51321/APP/2025/2991 - Haydon House, Joel Street - Design Comments

This revised proposal is broadly supported, subject to the following few queries / comments below.

PROPOSED GROUND FLOOR PLAN

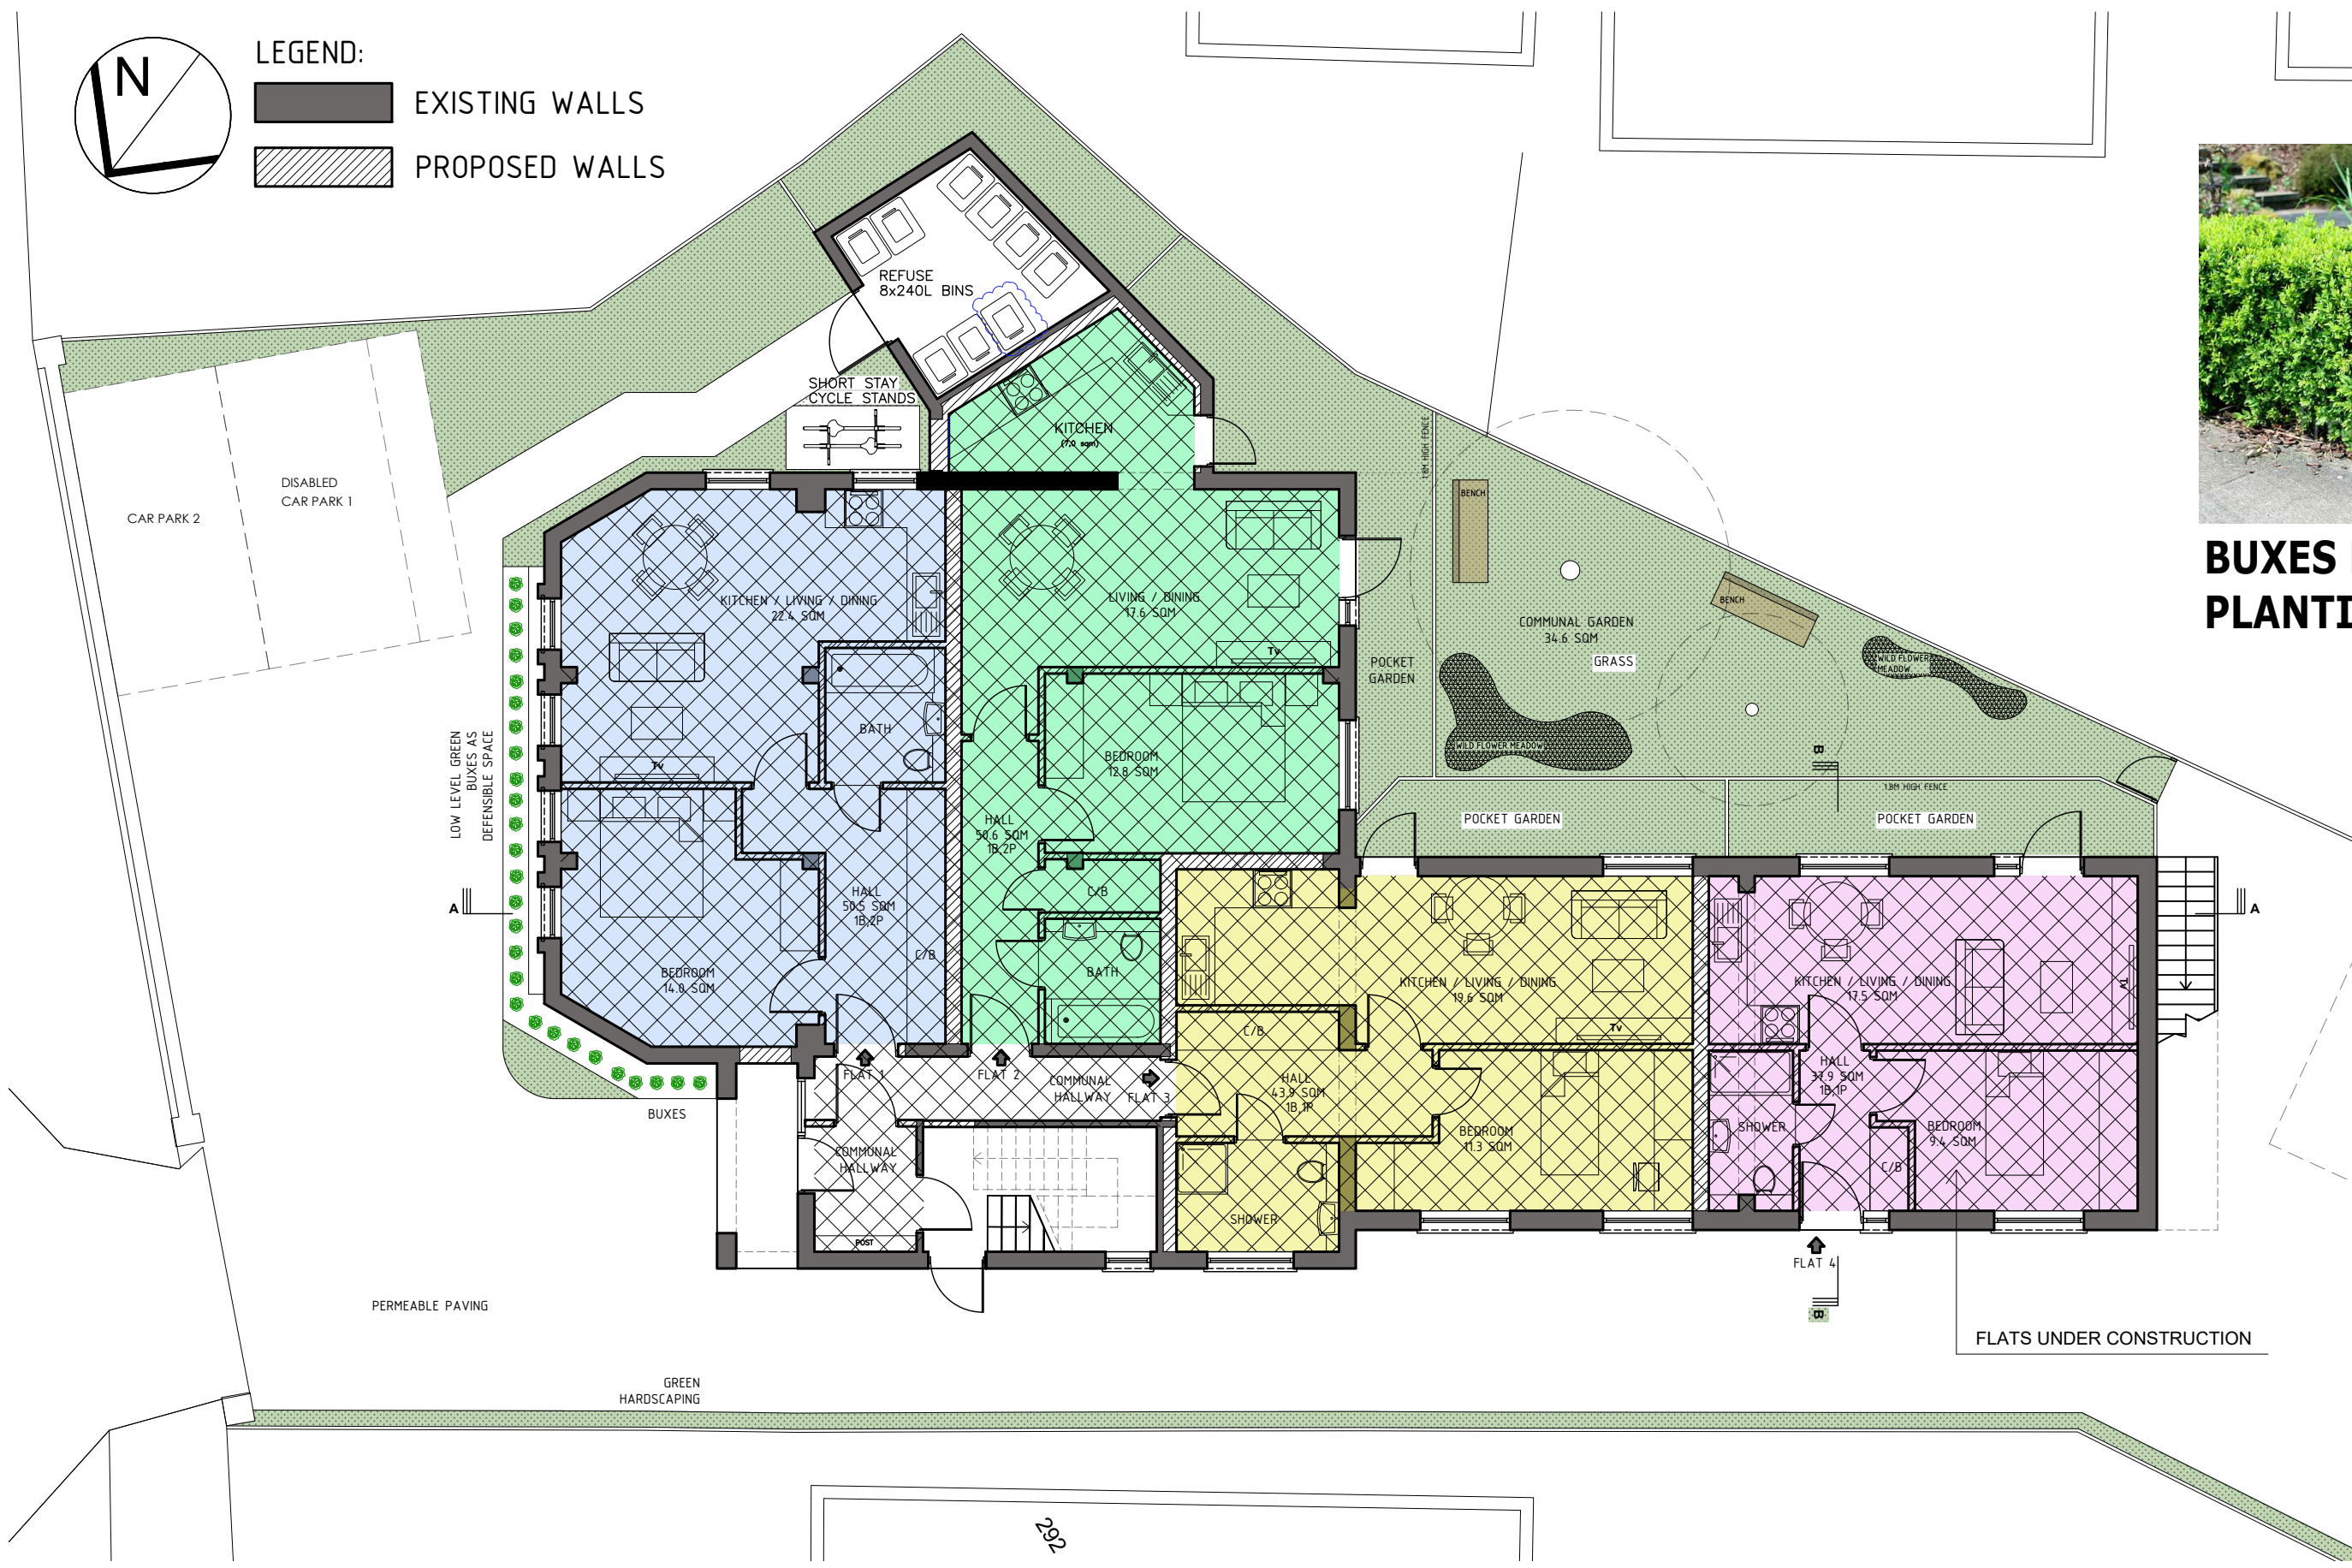
While we acknowledge the minor improvements to be delivered within the existing communal amenity area at rear, our previous comments regarding the existing / proposed landscaping remain outstanding / largely unaddressed. Given the proposal results in increasing capacity on site, some further improvements to the existing landscaping / forecourt area may be beneficial.

PROPOSED LOFT FLOOR PLAN

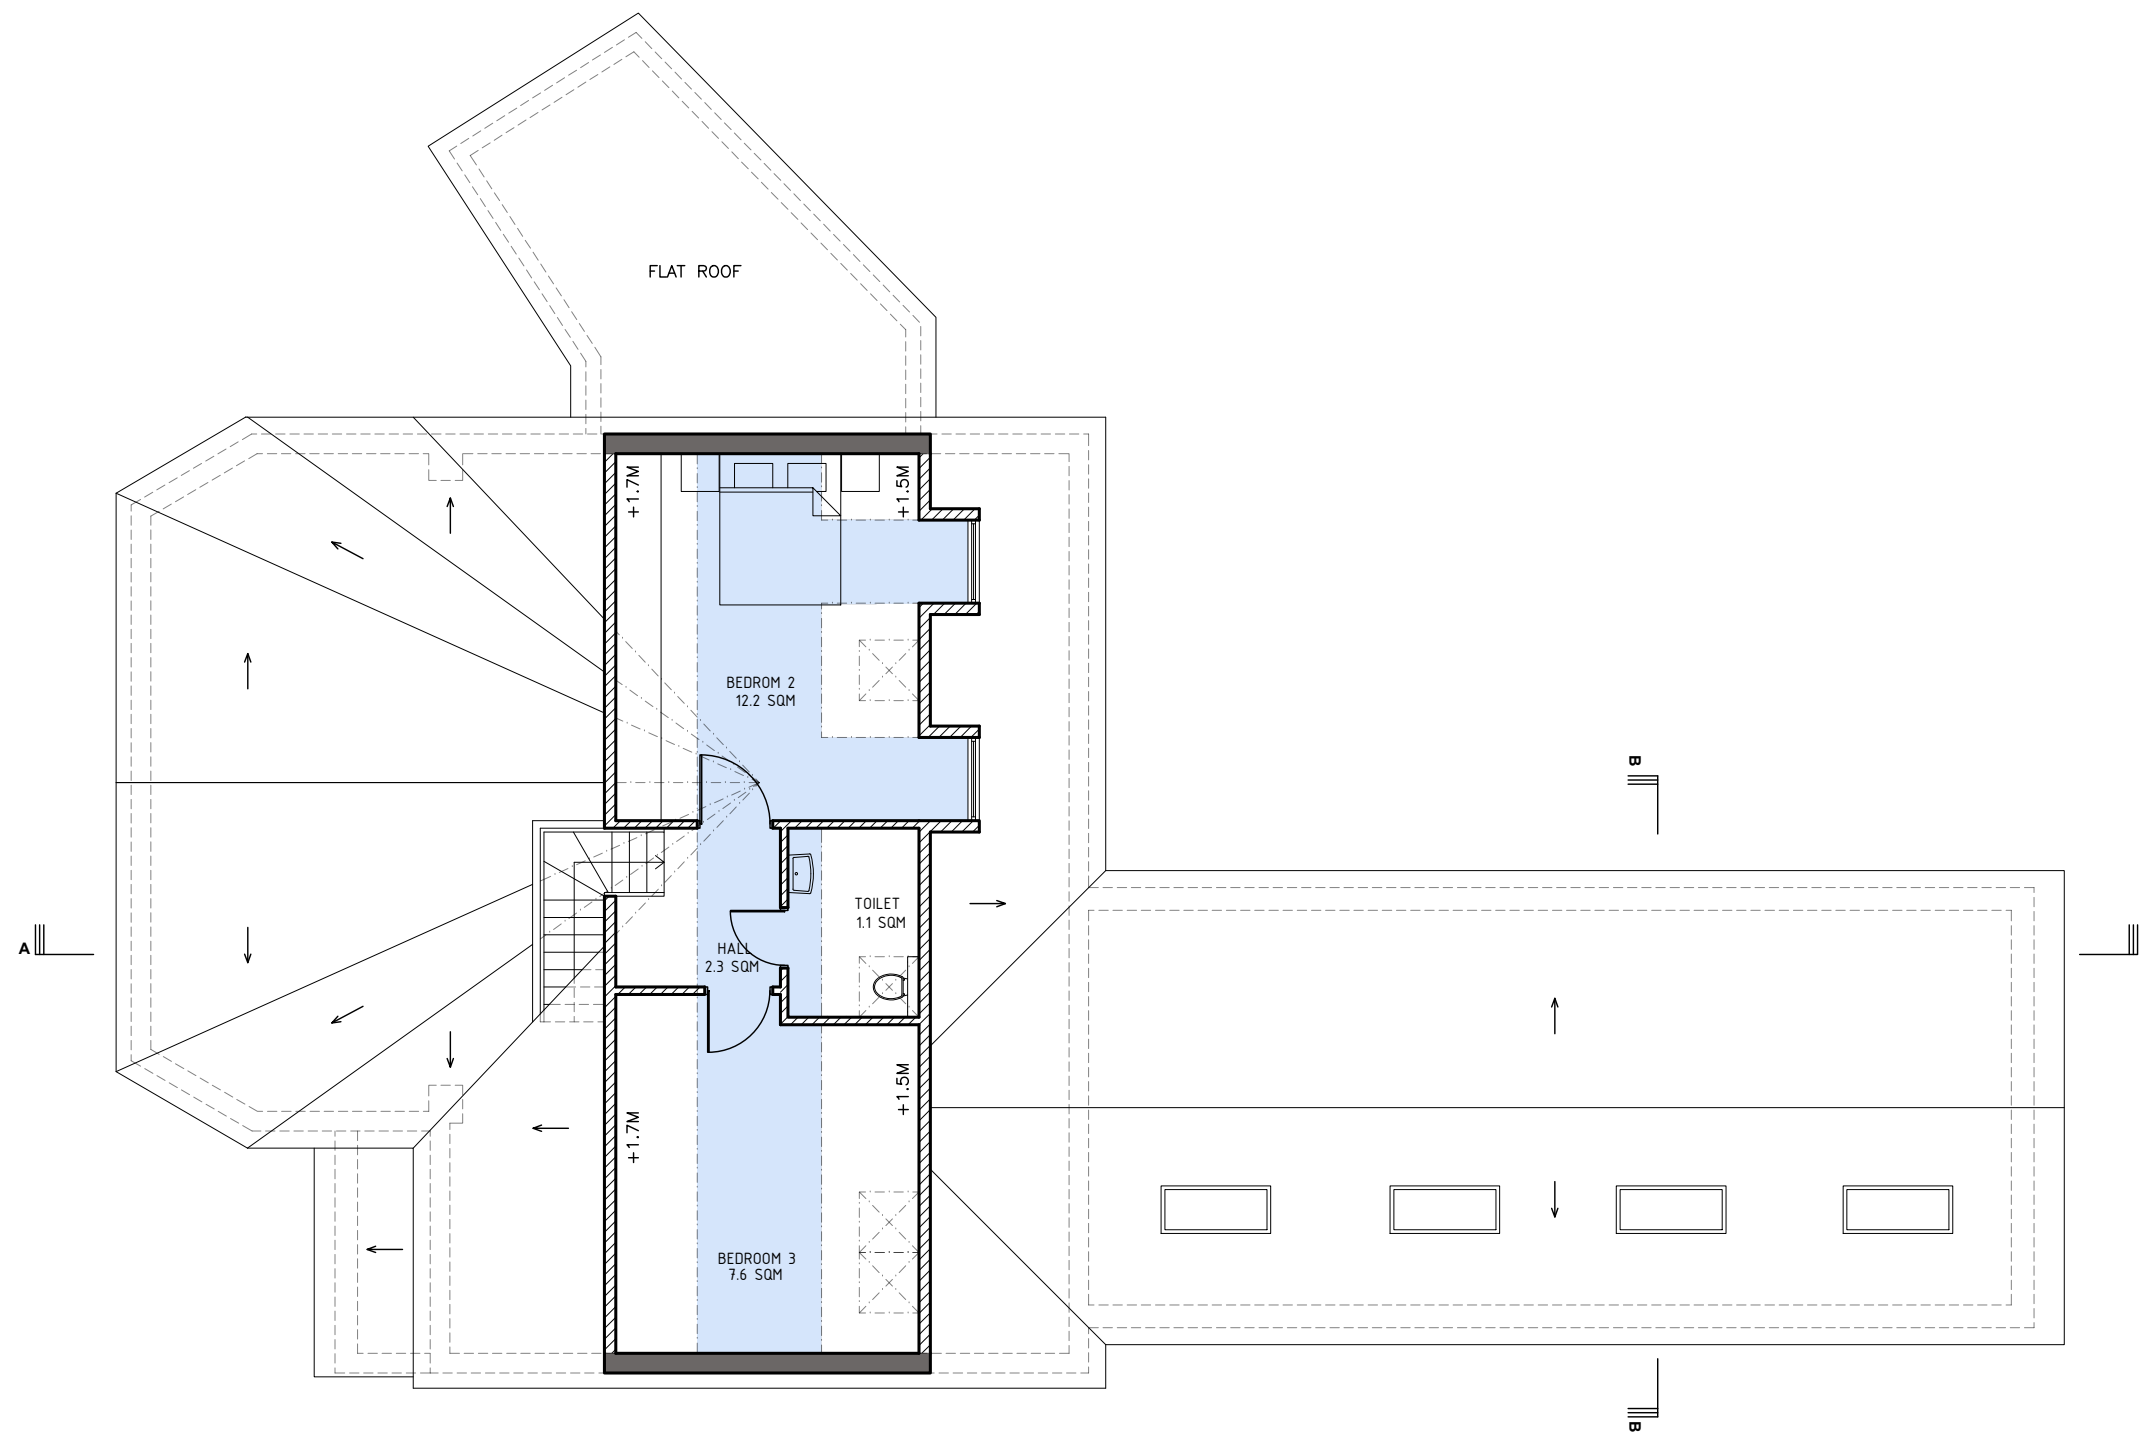
There is some concern that the proposed roof loft accommodation is low quality due to excessive bulkheads and impact on headroom. Furthermore, the provided 'storage' is rather excessive and risks being used as an unauthorised additional bedroom.

PROPOSED SECTION A-A

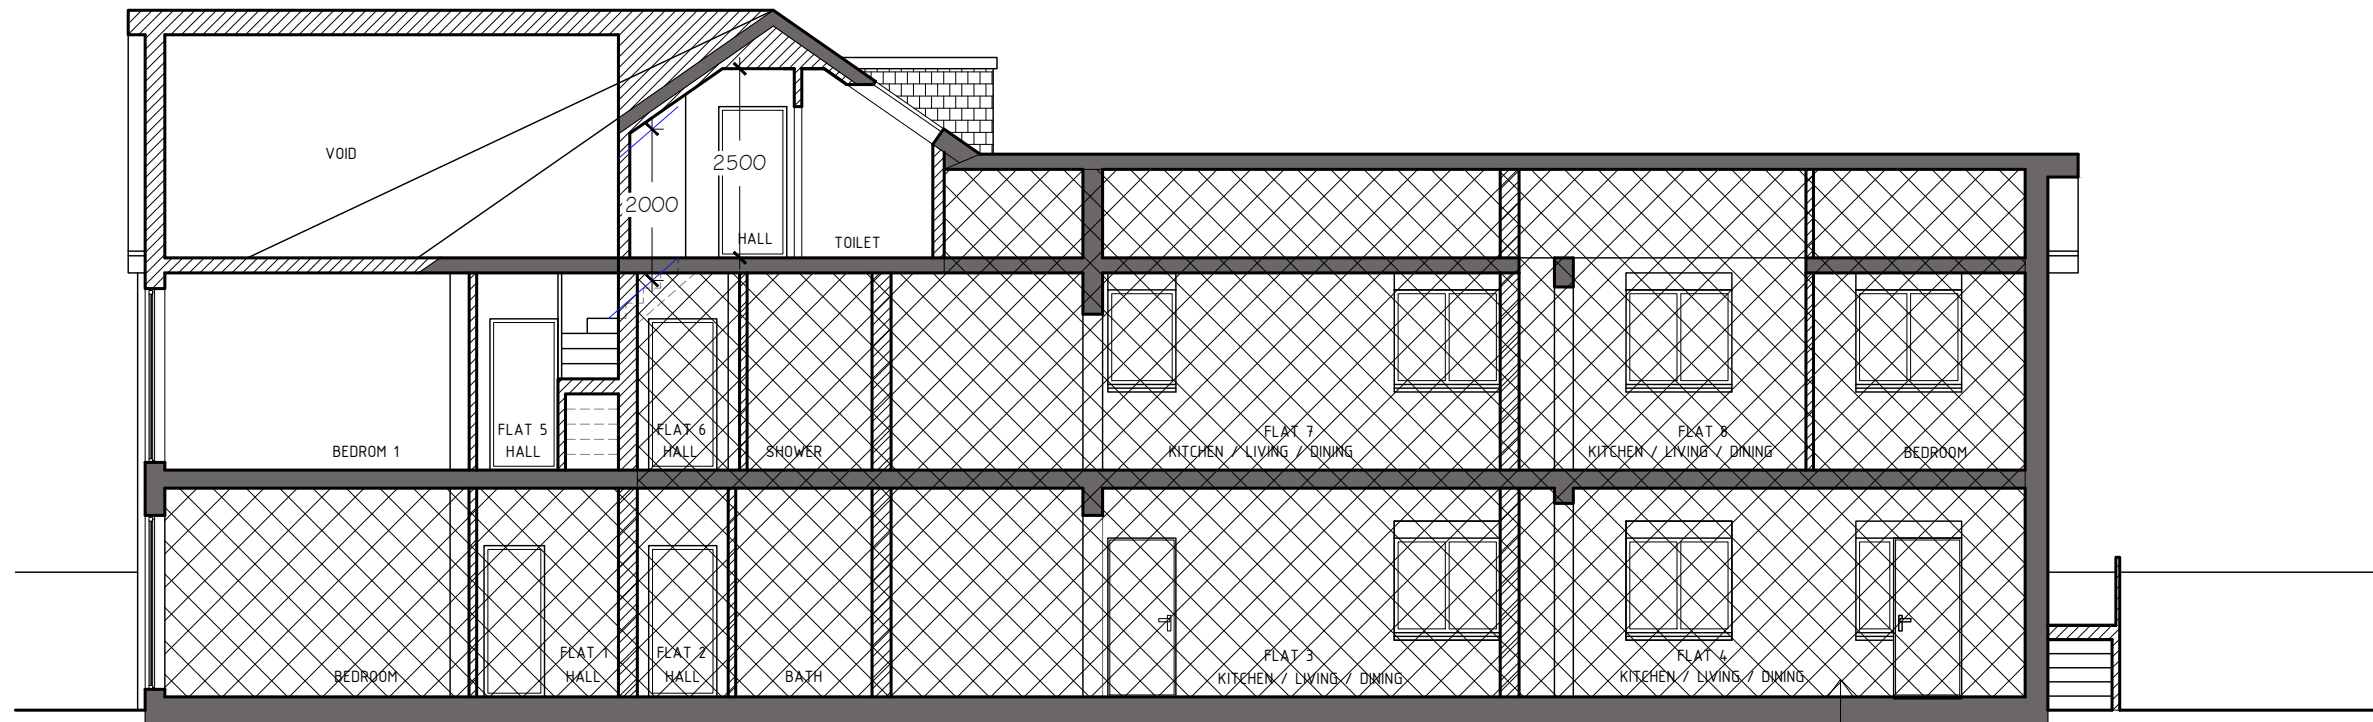
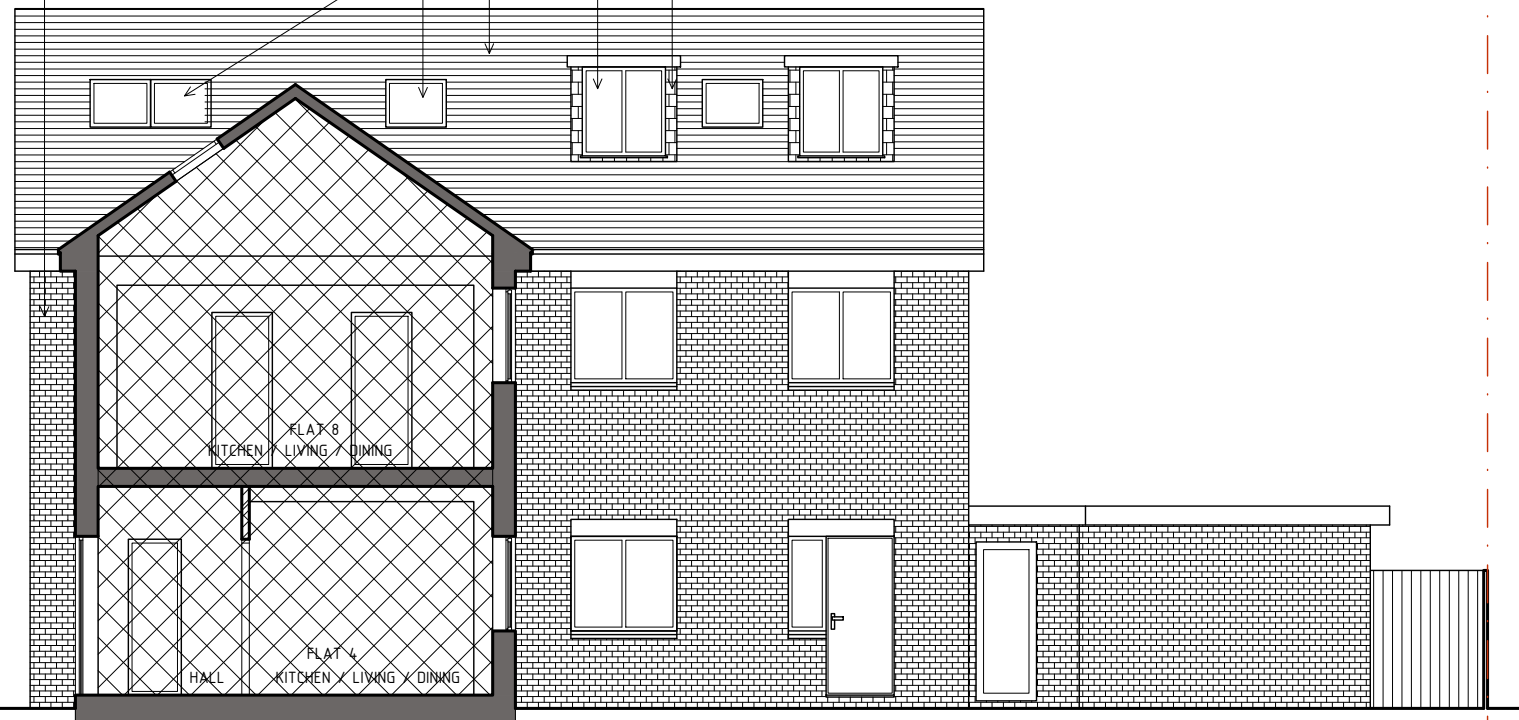
There is a query regarding whether the internal stair can achieve the required 2m headheight without altering the external roof form. Further design information regarding this element of the proposal may be beneficial (e.g. sections and plan drawings zooming in on that element demonstrating headheight and roof build-up can be accommodated within the proposed roof form).
